RESPONSE TO NOTICE OF EXHIBITION – SSD 6387 BURROWAY ROAD SYDNEY OLYMPIC PARK

The Sydney Olympic Park Authority (SOPA) has reviewed the submitted application and wishes to raise a number of areas of concern/non-conformance with the proposed development.

DRAWING TITLE  
**WINTER SOLAR STUDIES**

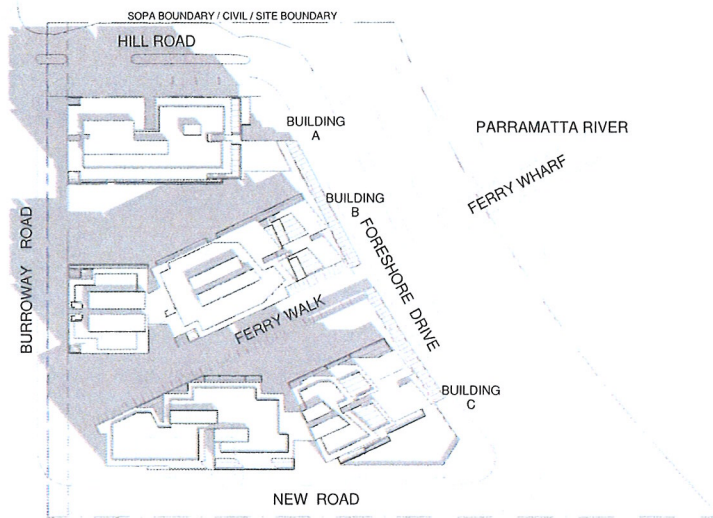
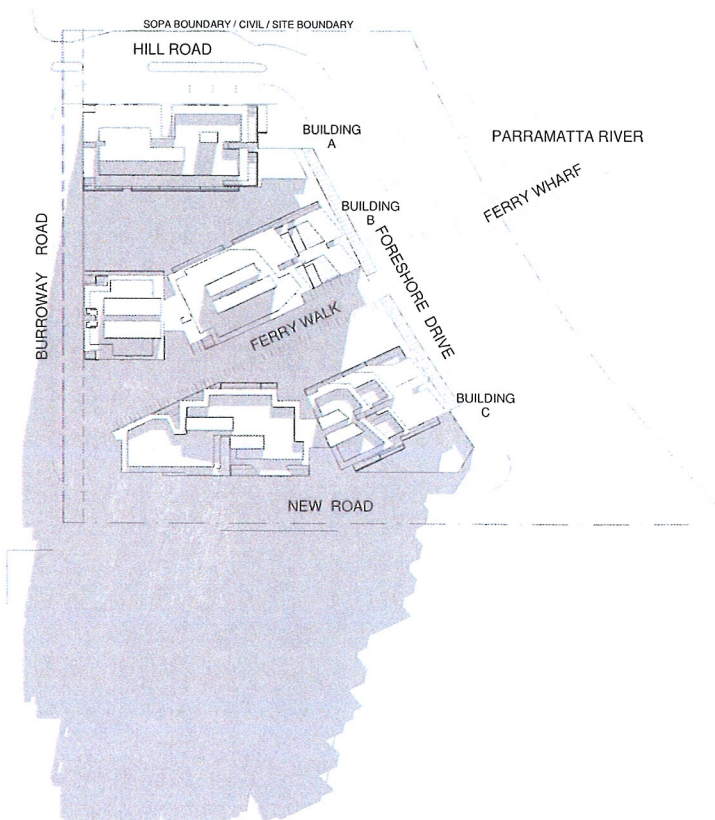
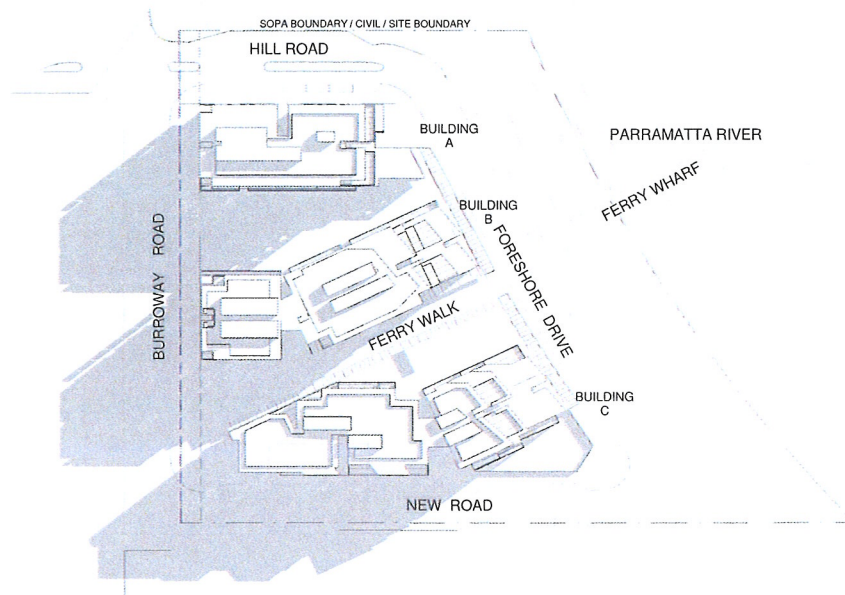
The proposed development has adopted the provisions of the Residential Flat Design Code (RFDC) for dense urban environments, thereby requiring the development to only provide 2 hours of sunlight to 70% of dwellings between 9am and 3pm on winter solstice. SOPA and the SOP Design Review Panel are of the opinion that Sydney Olympic Park is not a dense urban environment and all developments should achieve the target of 3 hours of sunlight between 9am and 3pm to 70% of dwellings. In addition the application does not include a solar assessment tabling details of when and how much sunlight individual units receive.
